Subject: R-6 Small Infill Design Review – 30 Merrill Street

Written by: Caitlin Cameron, Urban Designer

Date of Review: Wednesday, September 28, 2016

A design review according to the *City of Portland Design Manual* Standards was performed for the proposed new construction of a multi-family dwelling at 30 Merrill Street. The review was performed by Caitlin Cameron, Urban Designer, Nell Donaldson, Planner, and Shukria Wiar, Planner, all within the Planning Division of the Department of Planning & Urban Development. The project was reviewed against the *R-6 Small Infill Development Design Principles & Standards* (Appendix 7 of the Design Manual).

A
 1.3

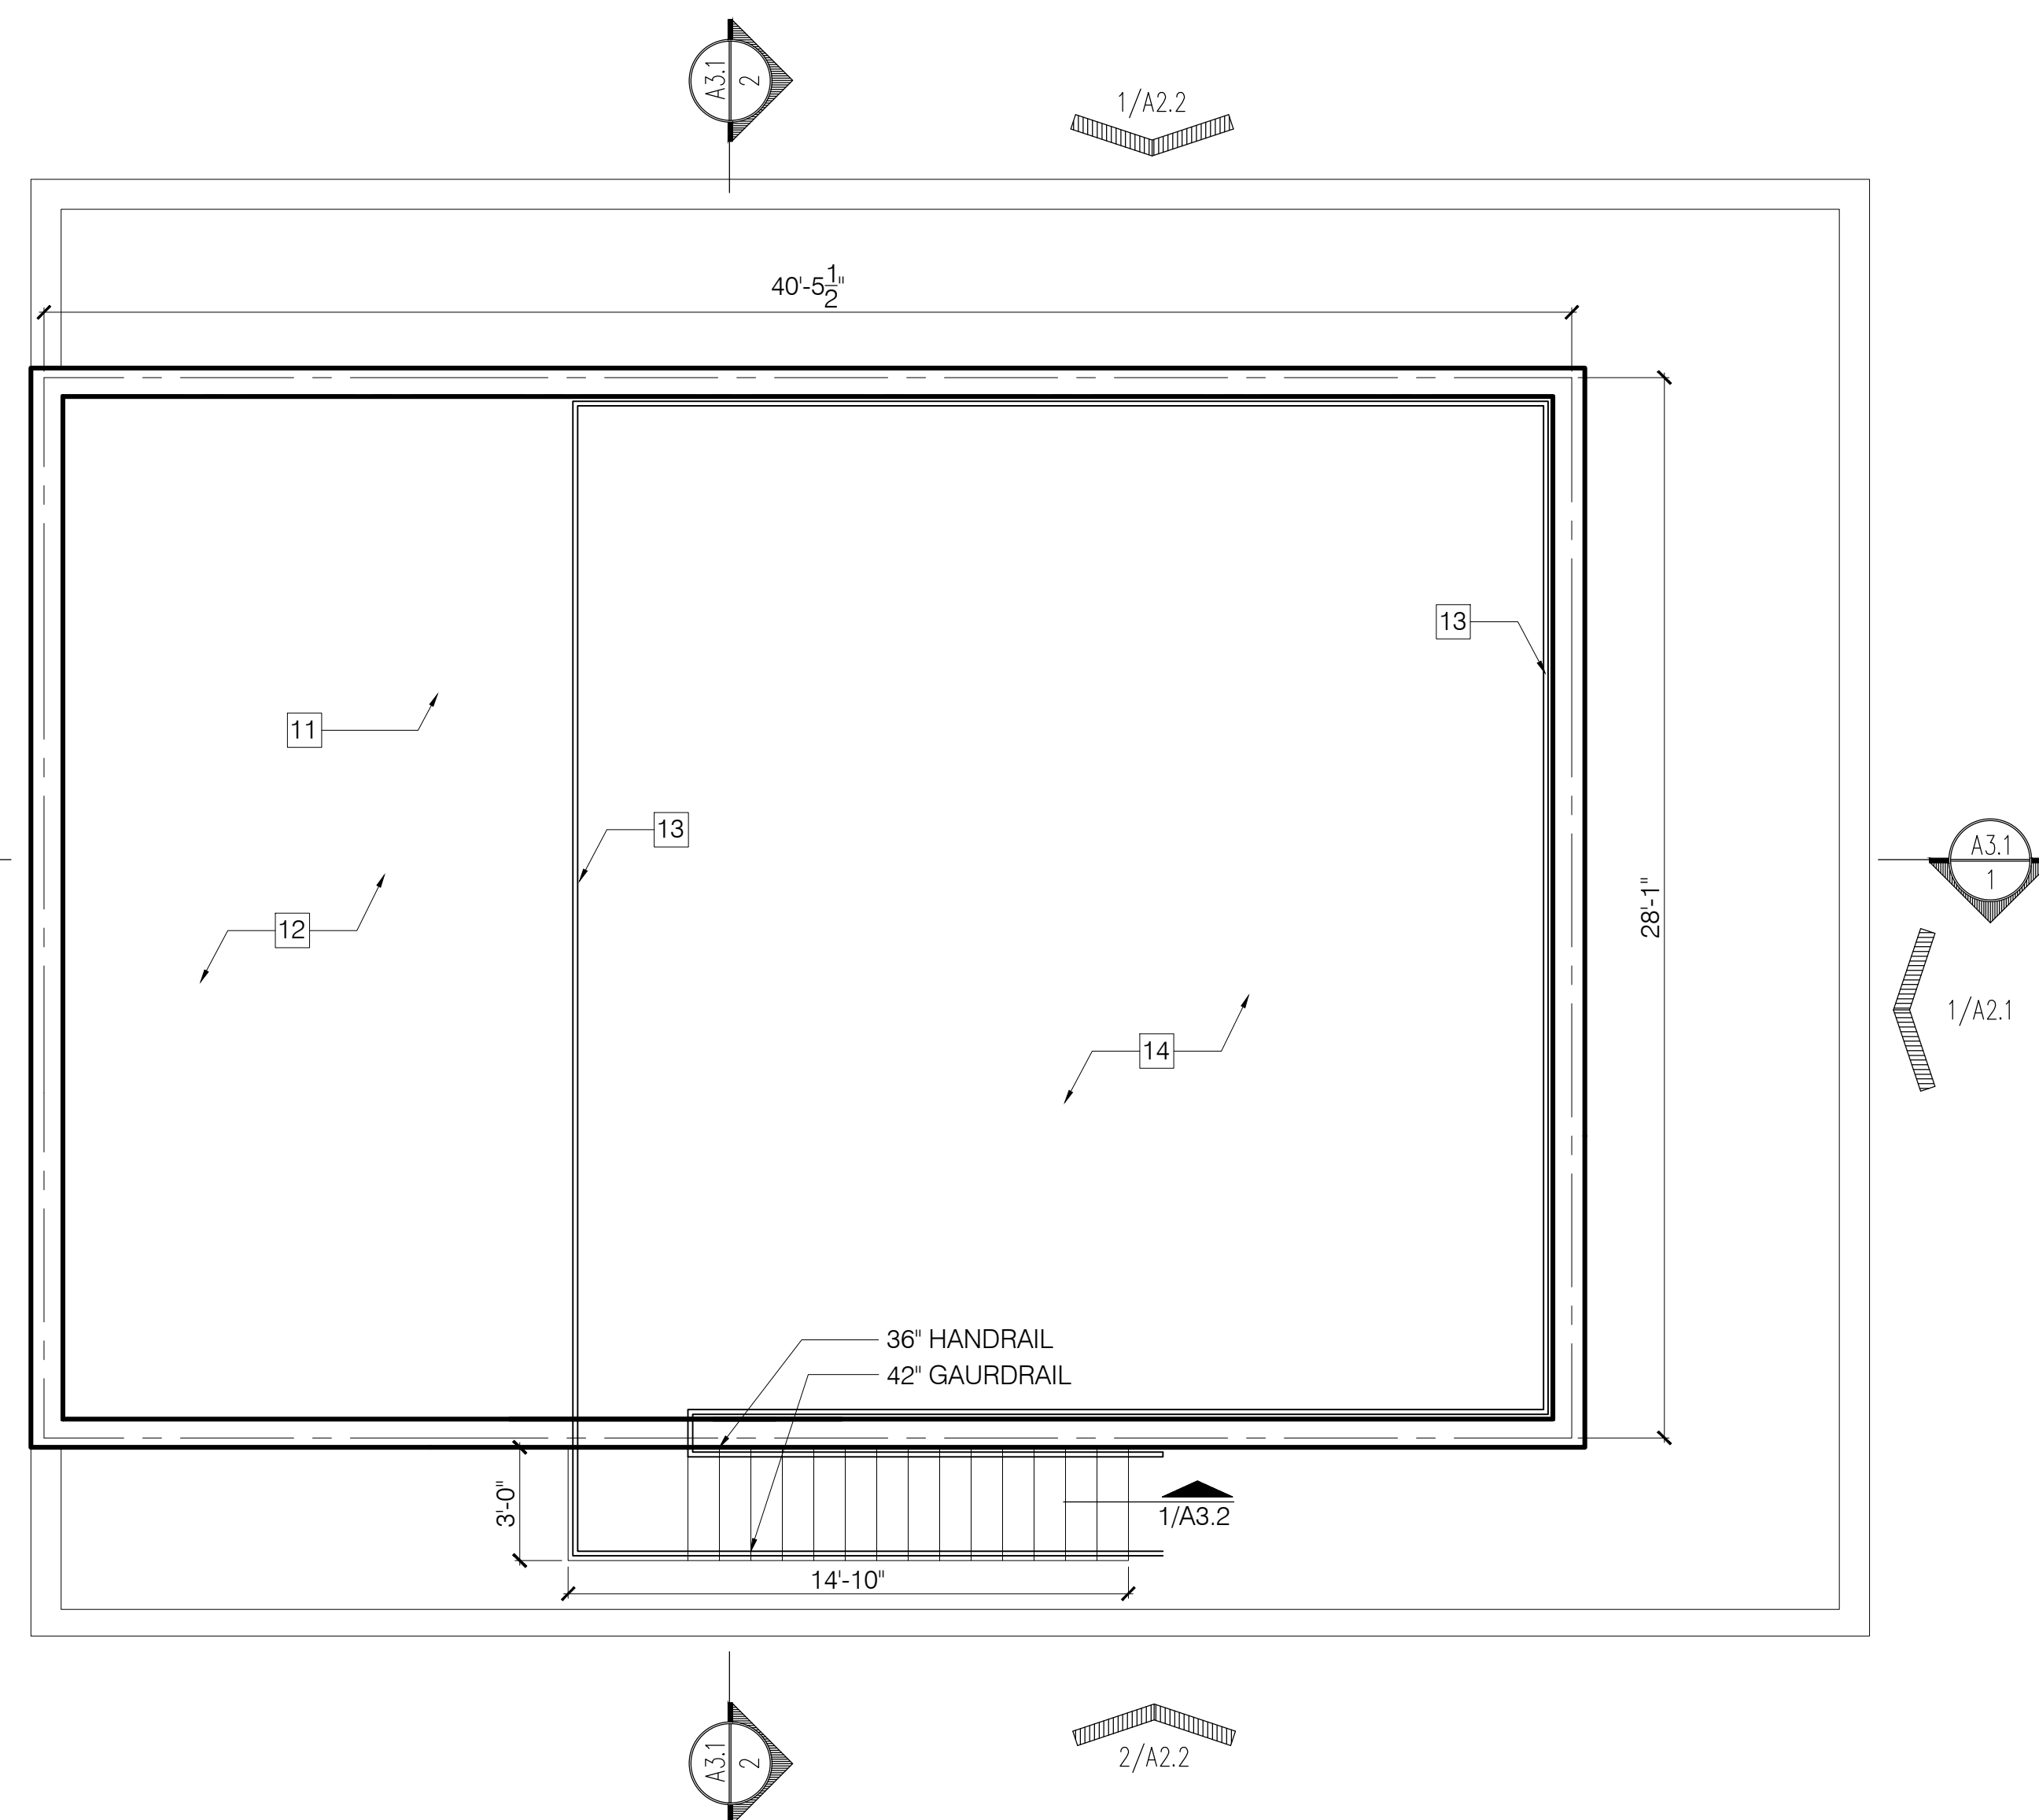
- *B-1 Massing:* The principal mass is reminiscent of a double triple-decker found in the context – revisions to the cornice line at the third floor, the stepback of the fourth floor unit help to emphasize that three-story contextual massing. A recess was added at the center of the mass to create recessed entry and provide a façade plane change creating a similar effect as a window bay.
- *B-2 Roof Forms:* The proposed 7th unit on the top floor has been centered and stepped back with a material change – these three actions make that fourth floor recessive and the flat roof form of the primary mass is dominant.
- *B-4 Roof Pitch:* The roofs are monopitch/ flat roofs.
- *B-5 Façade Articulation:* The project employs two of the required articulation elements – covered entry, recessed entry. Small balconies are also used.
- *B-6 Garages:* Not applicable.

- *F-6 Main Entries:* The main entry is emphasized with prominent placement facing the street, recessed, and the use of a canopy.
- *F-7 Articulation Elements:* The cornice has been revised to be more pronounced and have an overhang similar to those found in context multi-family buildings; the trim details are not clear; the façade offset is at least 12”.
